**Subject:** Proposed new duct, new joint boxes and replacement of joint boxes at Forestry Commission, Burley New Cottage, Burley Lodge, Burley BH24 4HS - Fibre to the Premises Burley V9018

Please find attached our proposed Civils Works to provide new PVC duct, new underground joint chambers and replacement of underground joint chambers at the Forestry Commission, Burley New Cottage, Burley Lodge, Burley BH24 4HS. This is required to provide Superfast Broadband/ Fibre to the Premises, the project will be known as Burley V9018m.

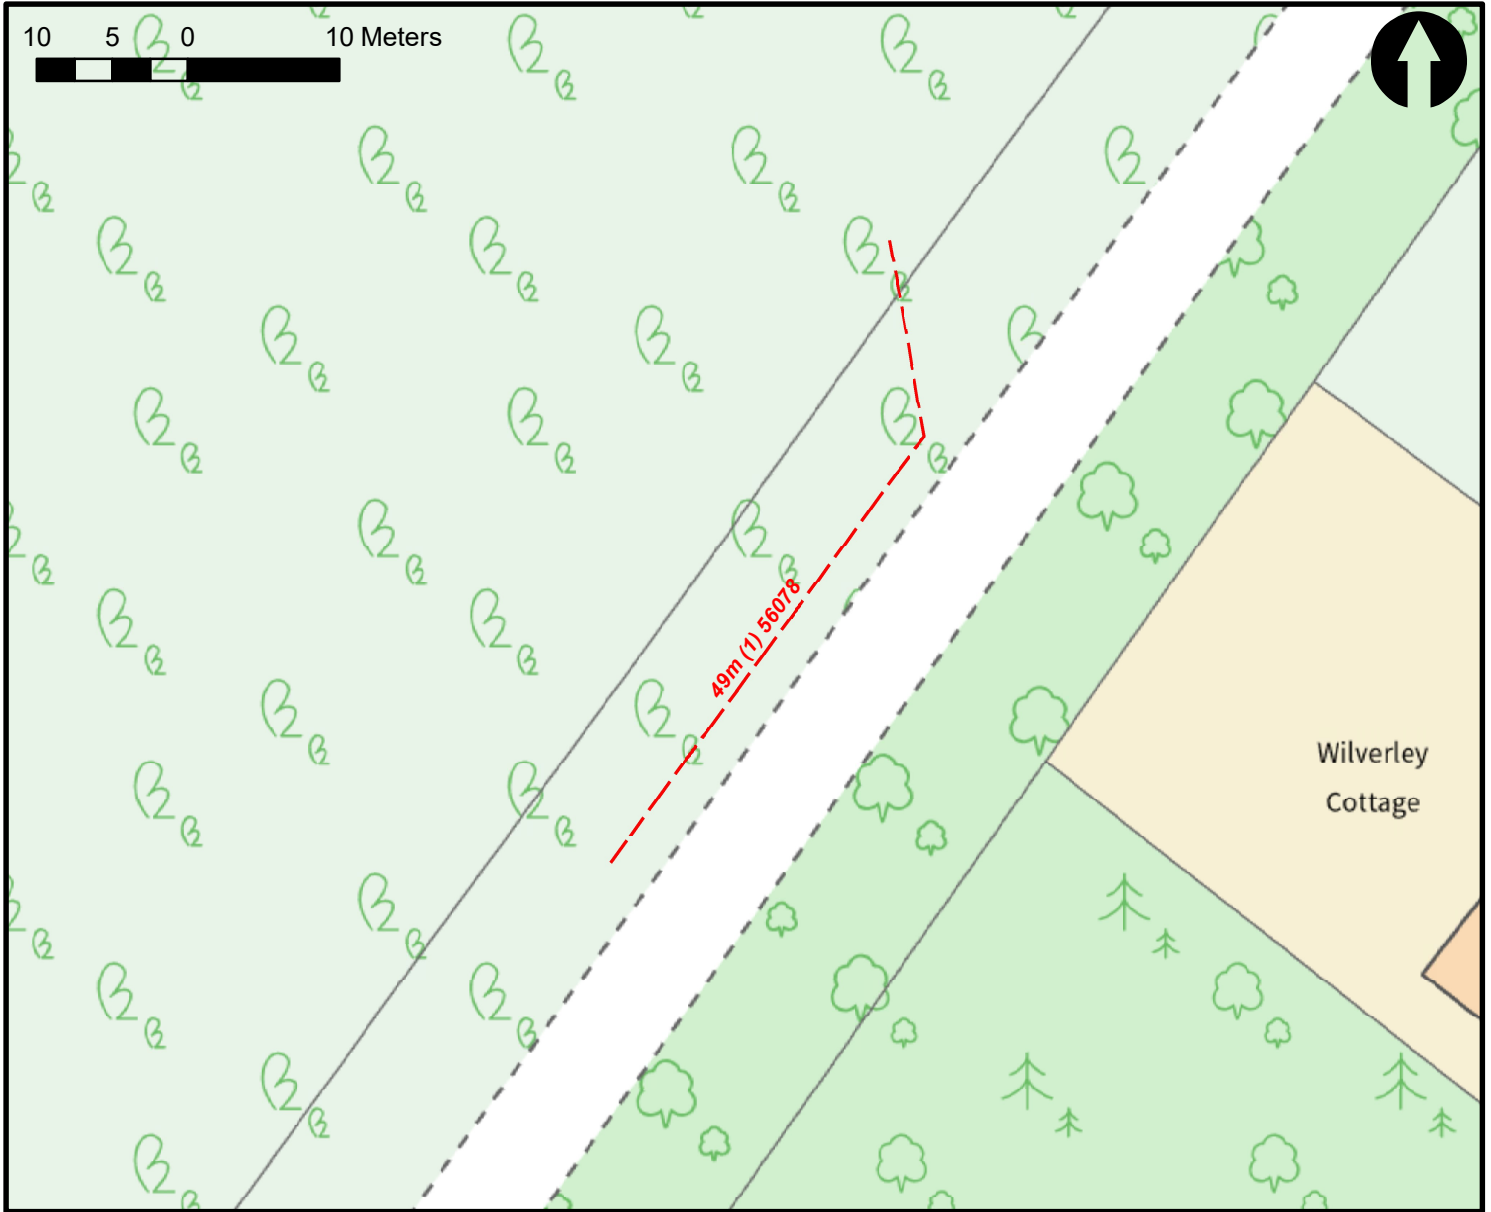
If we have given our consent previously then that stands even if you haven't yet carried out the work, so I think the Beechwood Lane one is fine. The Wilverley Cottage one is along the A35 verge and doesn't concern the Verderers. Now would actually be a very good time to get on with that, as the A35 is currently closed for the bridge replacement and the only traffic is the odd driver who thinks the road closed sign doesn't apply to them!
